**Natural England's response to G5.6 Indirect Effects of Forage Fish and Ornithology –  
Revision 1 [REP5-085]**

The construction and operation of Hornsea Project Four Offshore Wind Farm, located approximately 69 km from the East Riding of Yorkshire in the Southern North Sea, covering an area of approximately 468 km<sup>2</sup>.

Planning Inspectorate Reference EN010098

27<sup>th</sup> July 2022

Figure 4: Flamborough Front position variability based on data from Miller and Christodolou (2014).

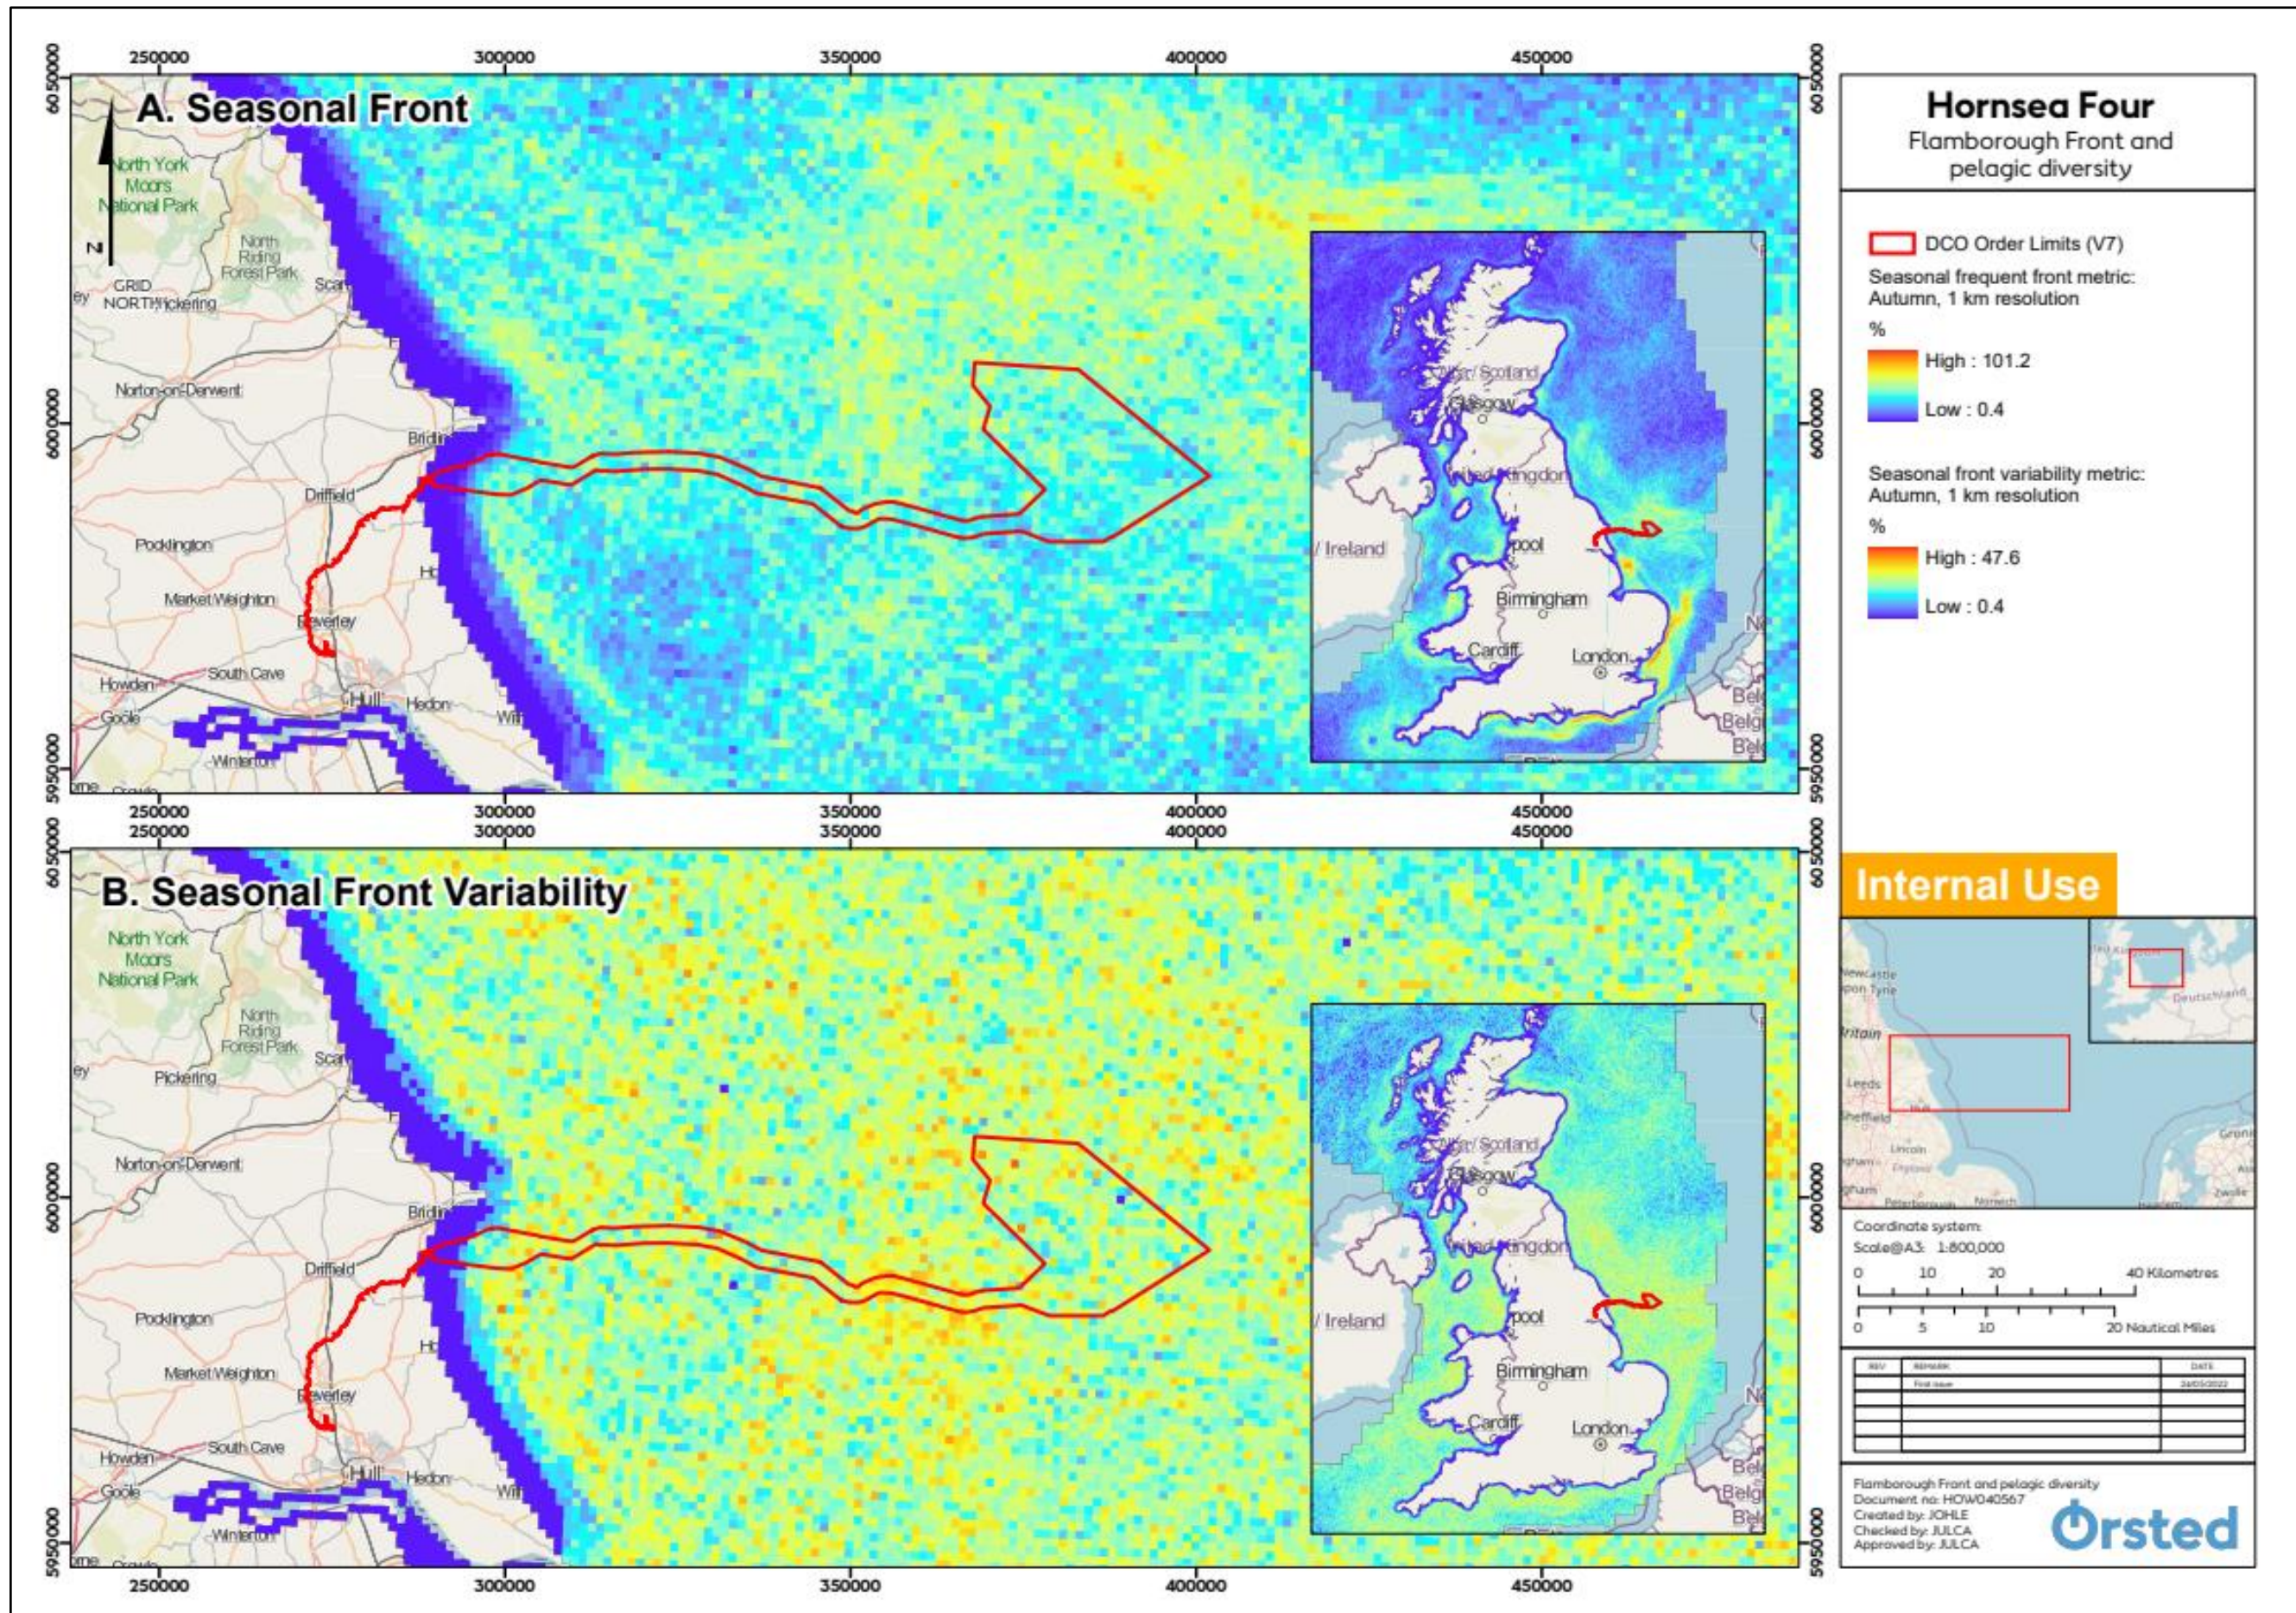
We do not consider this conclusion can be drawn with much confidence. The Applicant usefully highlights that there is a high degree of interannual variability in the timing, position and extent of the Front. Accordingly, it seems likely that there is interannual variability in the distribution and abundance of forage fish and therefore of the seabirds that feed on them. The link made between water depth and the formation of the Front is entirely plausible, however as with other factors, this is likely to operate at a broad scale. Given the water depth across the Hornsea 4 array area is still fairly shallow compared to the deeper water to the north, again we advise that drawing detailed spatial conclusions is not really justified.

Figure 6: Forage fish nursery grounds in relation to the northerly and southerly extents of the Flamborough Front.

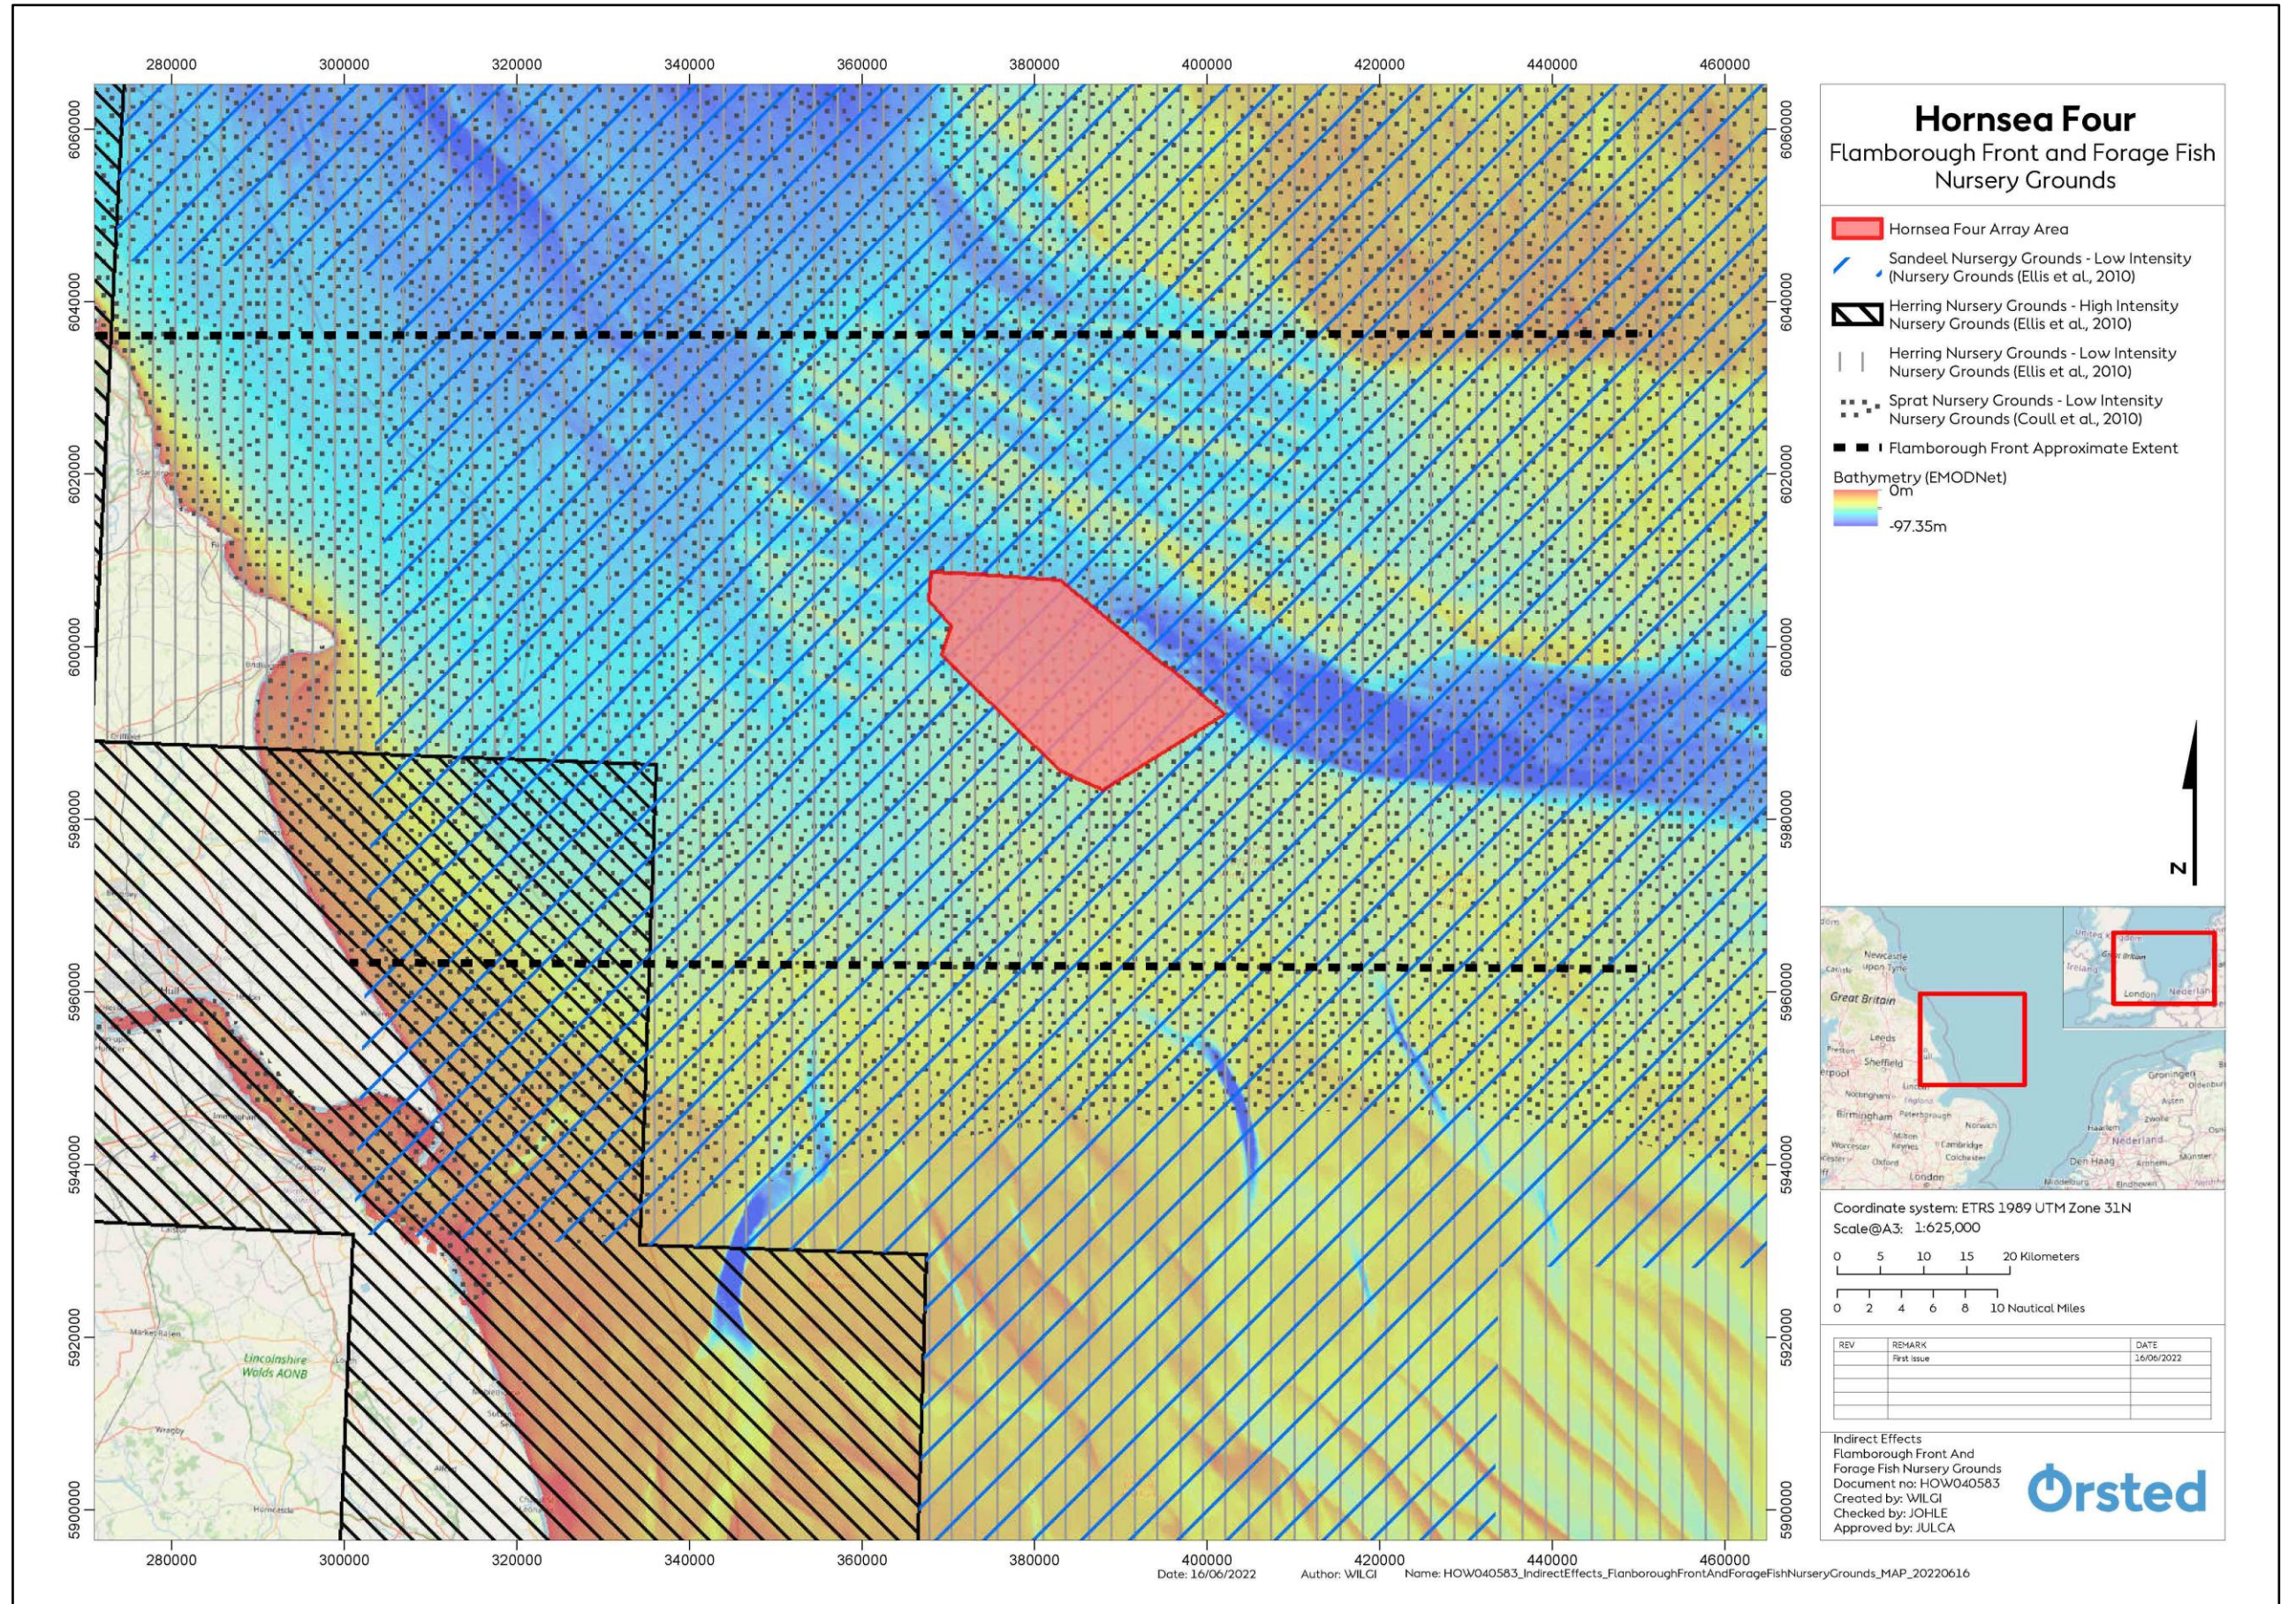
Reflecting the overall paucity of fish data available, the report focusses on three species of fish which are both commercially targeted and are key prey items for Flamborough and Filey Coast Special Protection Area (FFC SPA) seabirds. NE advises that these species are strongly suspected to have nursery grounds (and in the case of sandeel, residential habitats) in this general region of the North Sea (5.1.1.2). NE agrees with the numerous limitations presented on the use of Ellis et al. (2010, 2012) and Coull et al. (1998).
